Our Ref: R/2021/5/D & R/2017/28/E
File No: 2023/464259
Your Ref: SSD-19989744-Mod-1 & SSD-8993-Mod-4

**Advice on Modifications - SCEGGS Darlinghurst
SSD-19989744-Mod-1 and SSD-8993-Mod-4**

SSD-19989744 relates to the adaptive reuse of Wilkinson House and Modification 1 seeks consent for various internal and external changes, including increasing the lift shaft and lobby by 300mm.

SSD-8993 is the Concept SSD and Modification 4 seeks to amend the envelope to reflect the design changes sought under the Detailed SSD by increasing the height of the south-western portion of the envelope by 300mm.

DWG TITLE
WEST ELEVATION
DWG NO REV

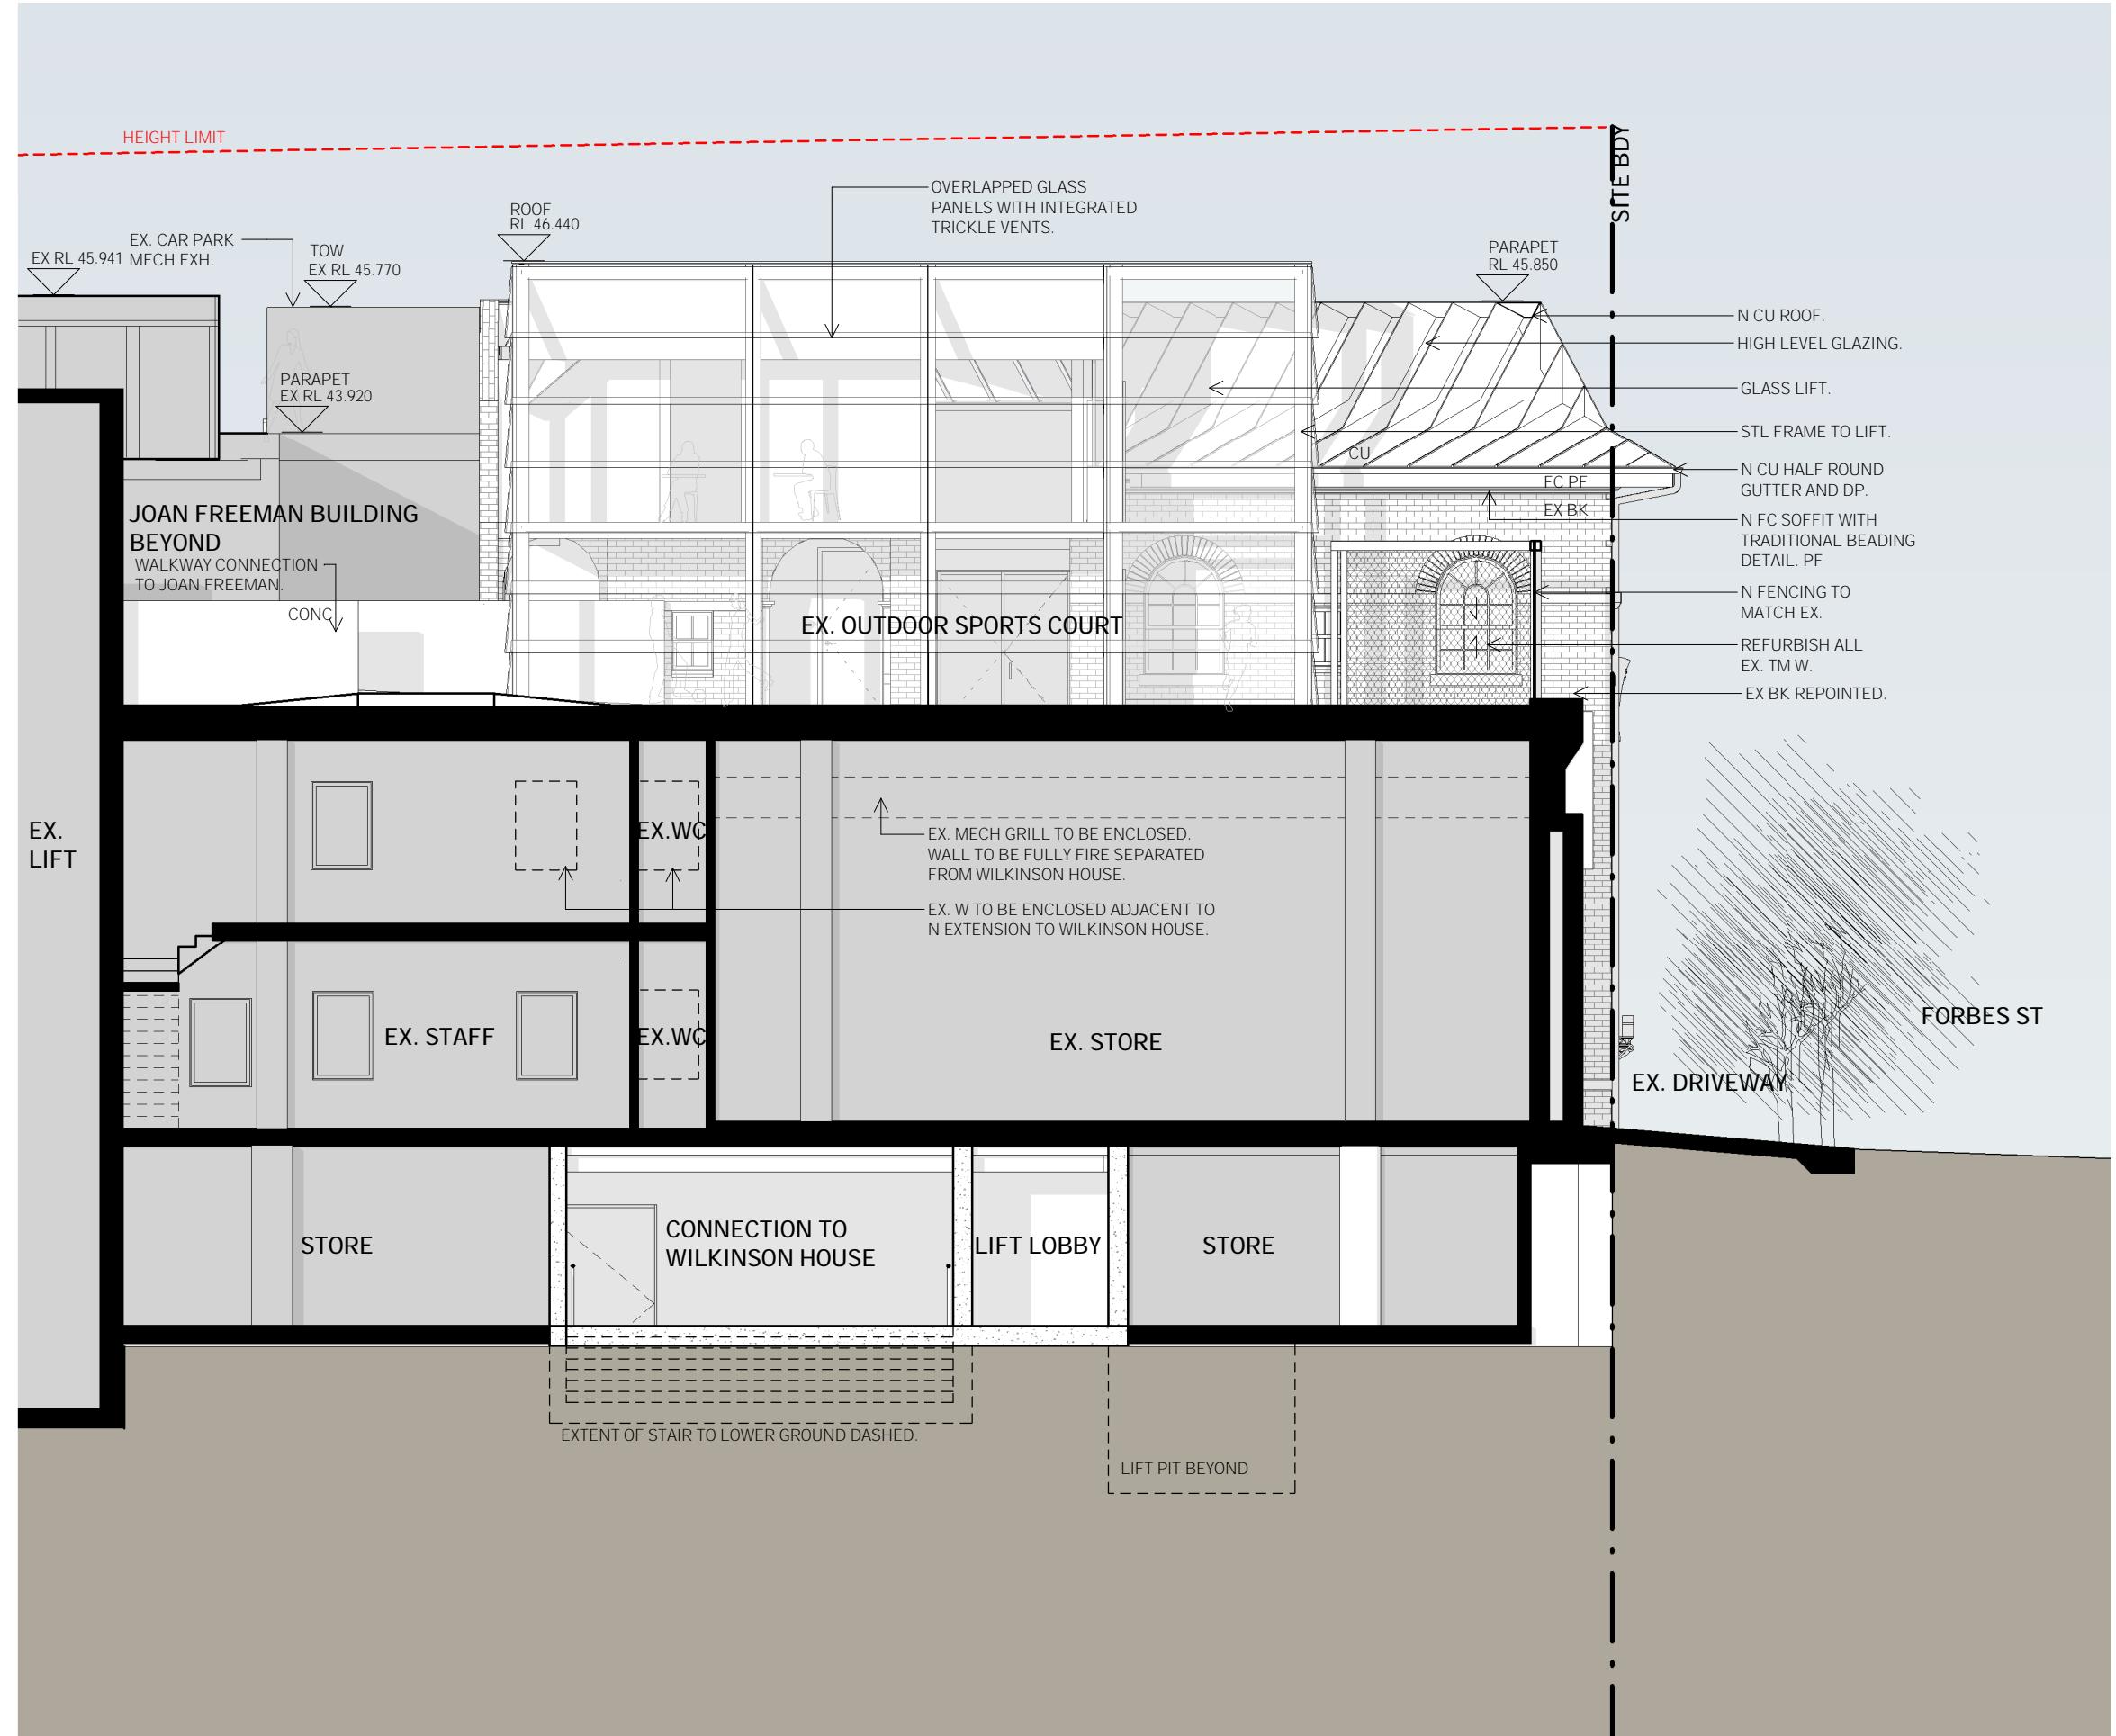
- The increase in the lift shaft width encroaches into the roof eave. While there are adverse visual impacts from the lift cutting into the roof and this is not an ideal design outcome, its visibility is minimal due to the setback from the street.
- The proposal includes changing the fascia cladding on the western elevation from copper to fibre cement with paint finish. The elevation highlights a portion of the changed materials closer to St Peter Street. It is recommended that this portion which has visibility from the street remain as copper cladding to maintain uniformity with the external roof material.

Figure 1: Portion of the western elevation that should remain as copper cladding.
